DISPLAY THIS CARD ON PRINCIPAL FRONTAGE OF WORK
CITY OF PORTLAND
PERMIT ISSUED

This is to certify that MCLAUGHLIN STEVEN M JOAN L MERRY MCLAUGHLIN J
has permission to Repairs for code violation
AT 45 GLECKLER RD 141 F041001

BUILDING PERMIT REPORT

REASON FOR PERMIT: To Construct Full dormer

FRAME DETAIL
SCALE 1/2" = 1'-0"

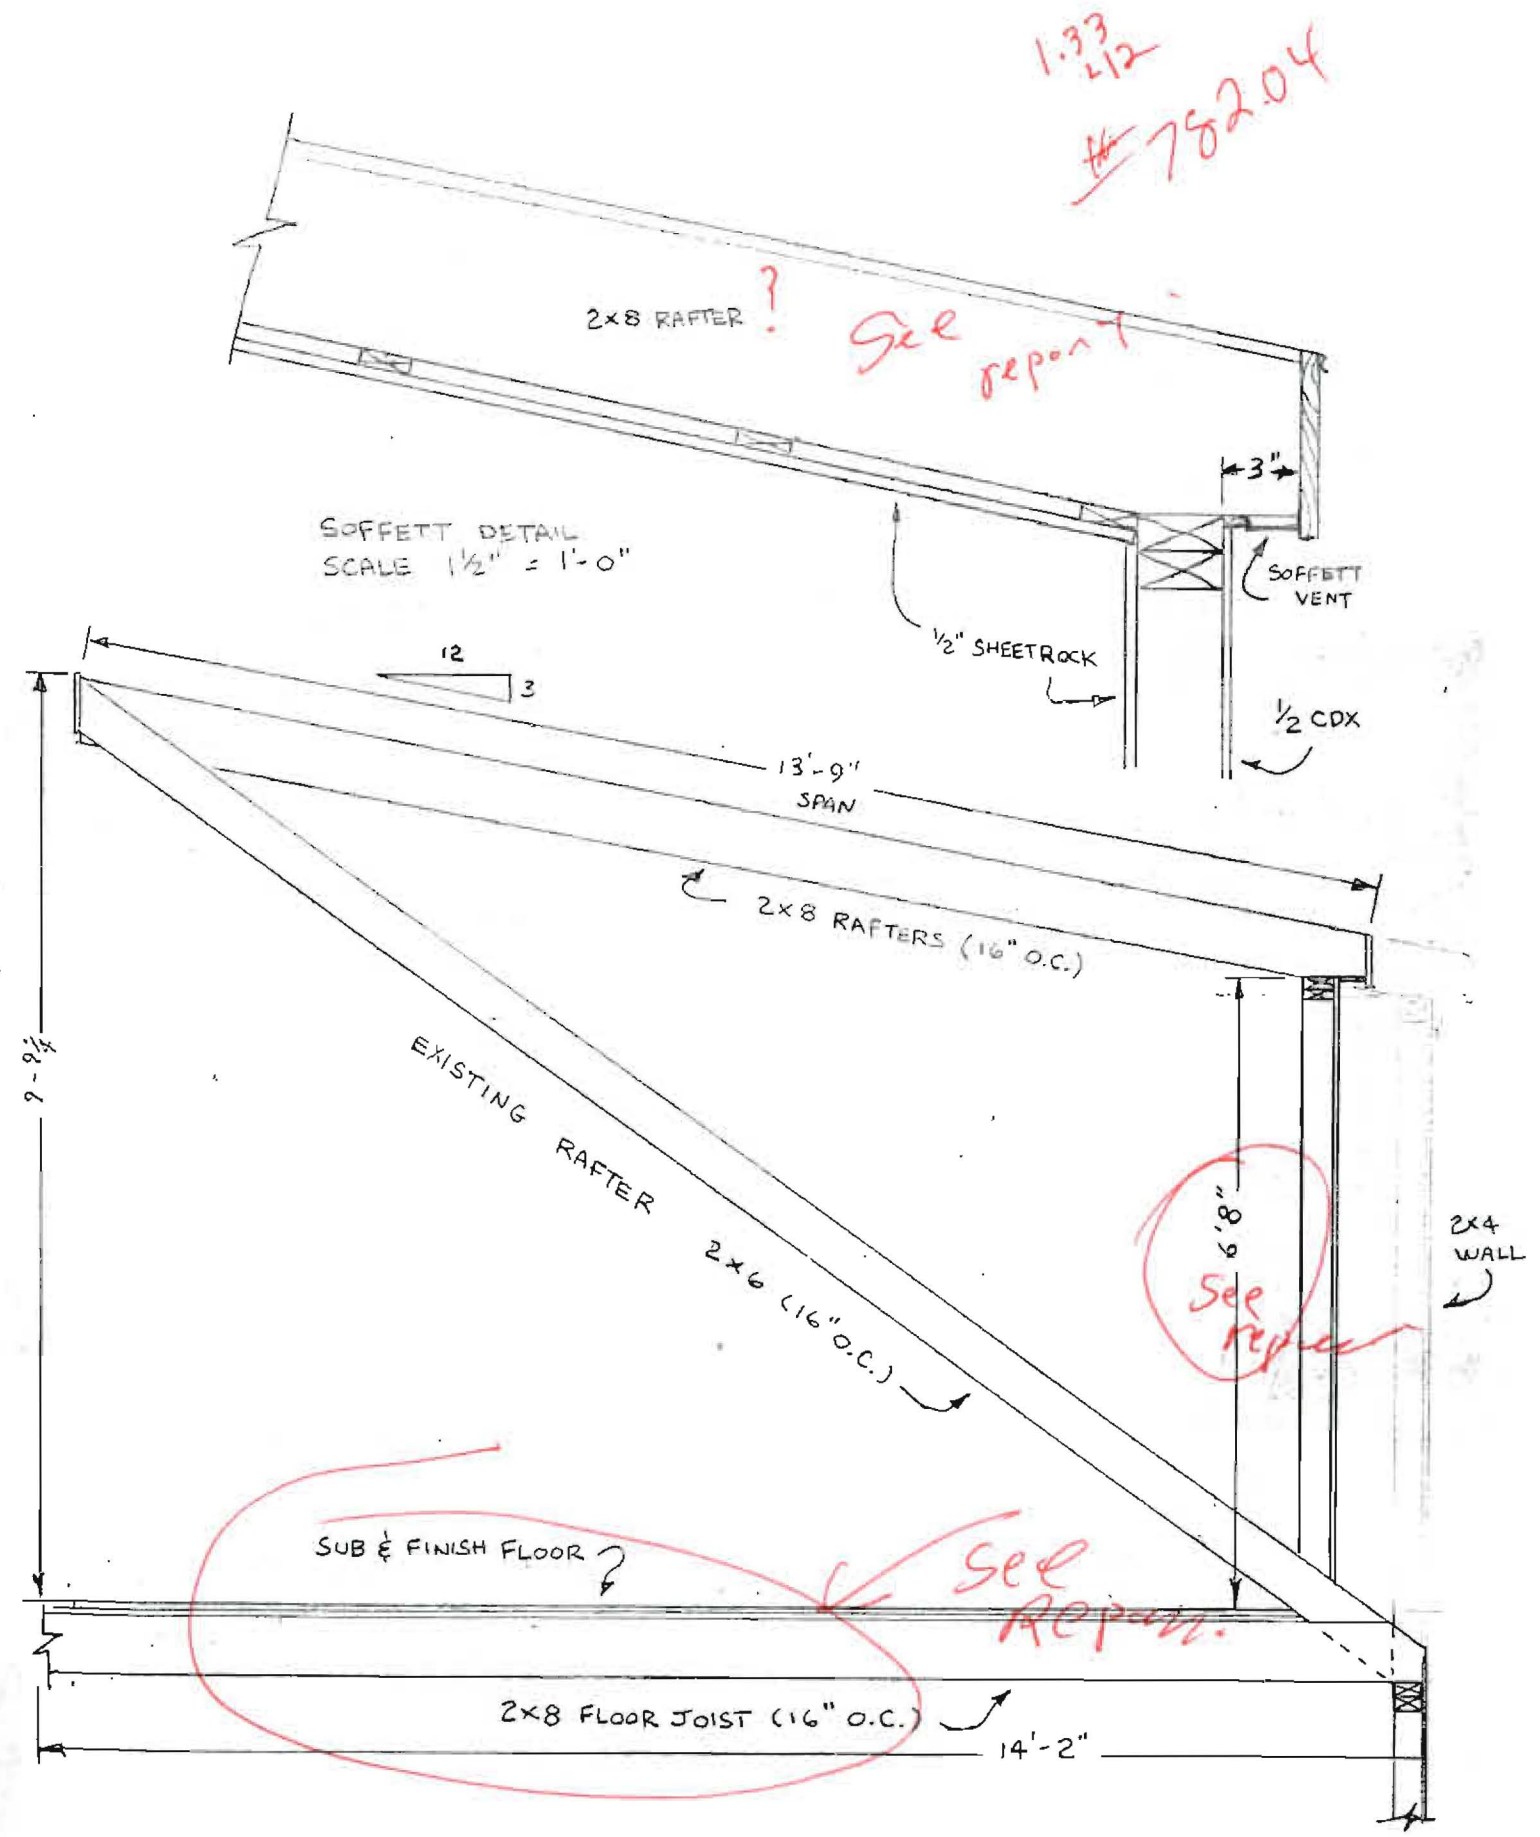
30. Glass and glazing shall meet the requirements of Chapter 24 of the building code.
- *31. The pro. Lied 2x8 rafters @ 16"OC spanning 13'9" does NOT meet the requirement of the bldg. Code - 2x8"@ 12"OC. 2x10"@ 16"O.C. will meet the Code -

- * 32. The 2x8" Floor joist @ 16"O.C. spanning 14'2" with a 30 LL exceeds the bldg. code - you must submit revised plans showing an alternative method.
